**SSD-10346 for Oxley Solar Farm at Gara Road, Armidale
(Lot 1 & 2 DP1206469, Lot 5 DP 253346, Lot 6 DP625427, Lots 7003 & 7004
DP1060201)**

31 October 2022

TfNSW has reviewed the amended application and supporting documentation submitted and is not satisfied that the proposed development has adequately addressed the anticipated construction traffic impacts to ensure that the new access can provide safe and practical access.

Figure 2 Armidale Regional Landfill Access Road

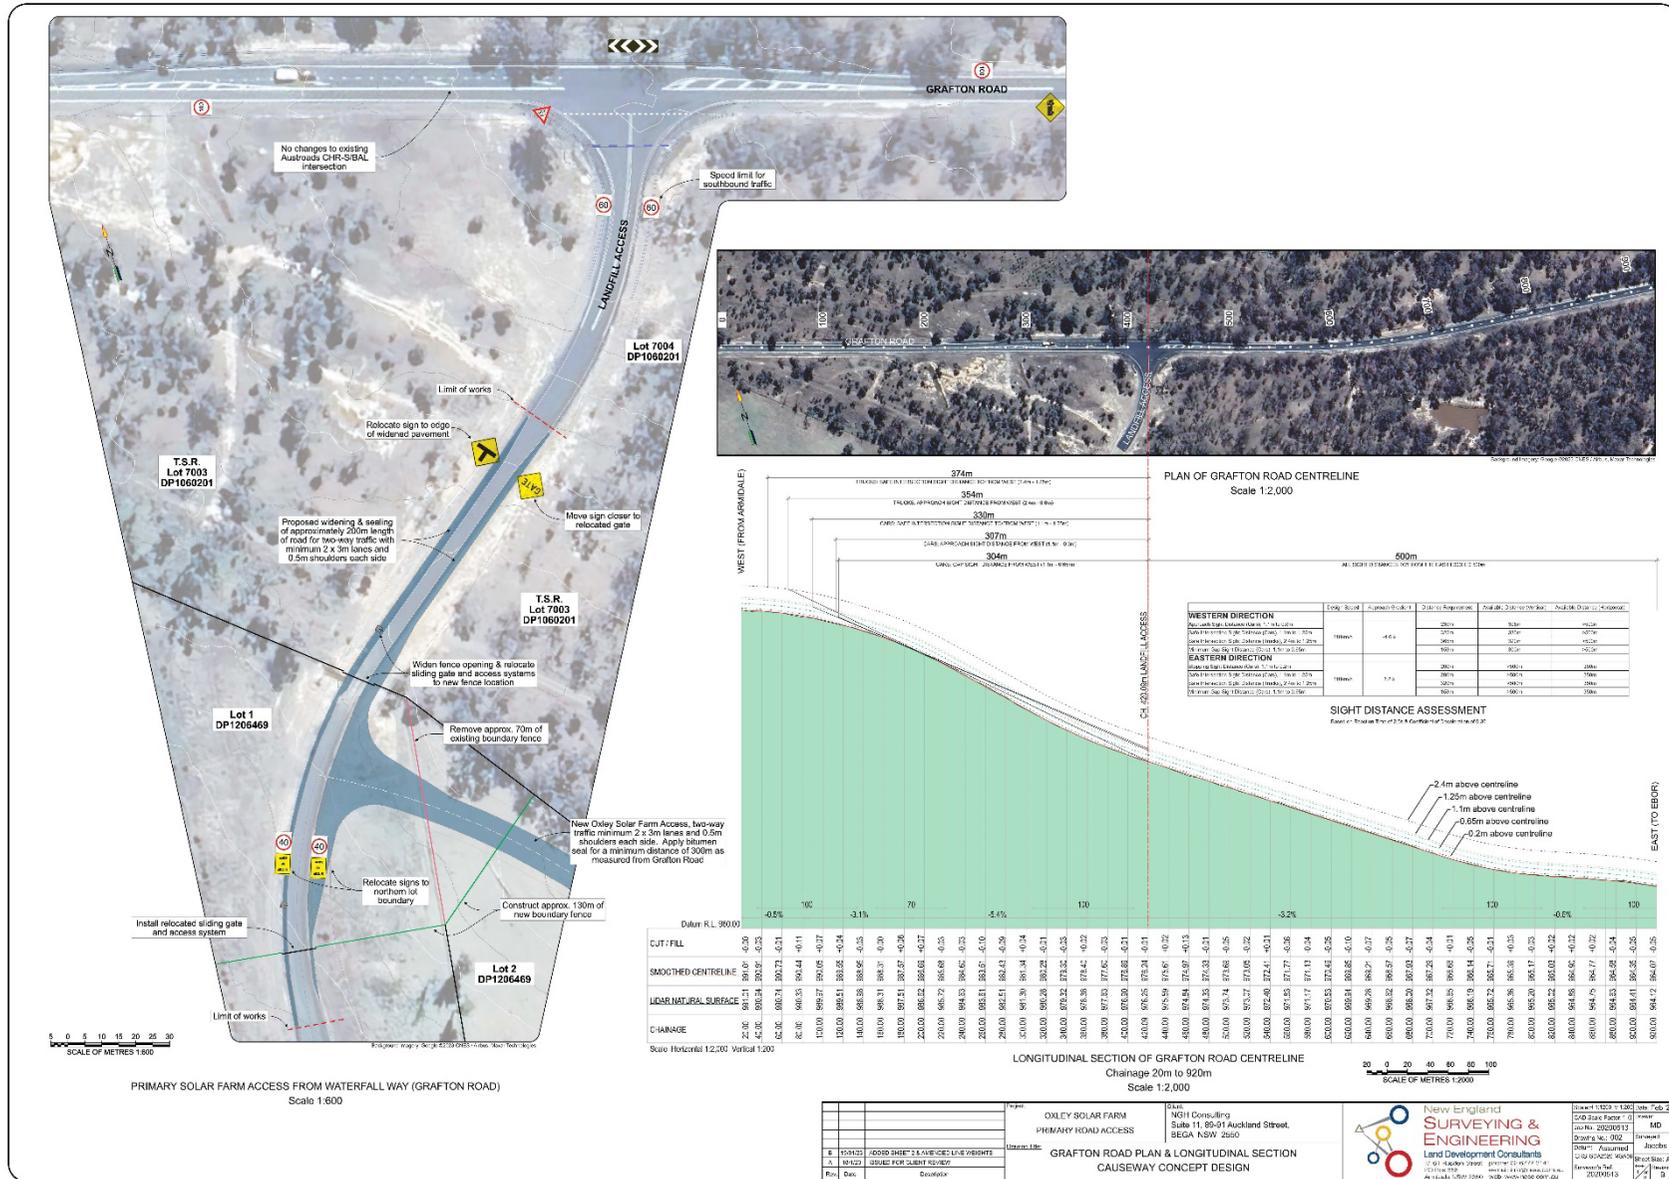
- A scaled strategic design illustrating the full scope of road works at the ARL access road as identified in the TIA, demonstrating the required Safe Intersection Sight Distance (SISD) (110km/h design speed) and swept paths of the design vehicle (including Over Size Over Mass vehicles). To assist you in preparing the designs, please refer to link: <https://roads-waterways.transport.nsw.gov.au/business-industry/partners-suppliers/documents/planning-principles/strategic-design-fact-sheet-02-2022.pdf>

- The size of the BESS has increased yet the details of the associated transport vehicles and movements have not been identified. Further details are required to confirm the quantity, dimensions and overall mass of the relevant containers and proposed design vehicle dimensions including swept paths (for all directions) at the site access and at any pinch points along the transport route.
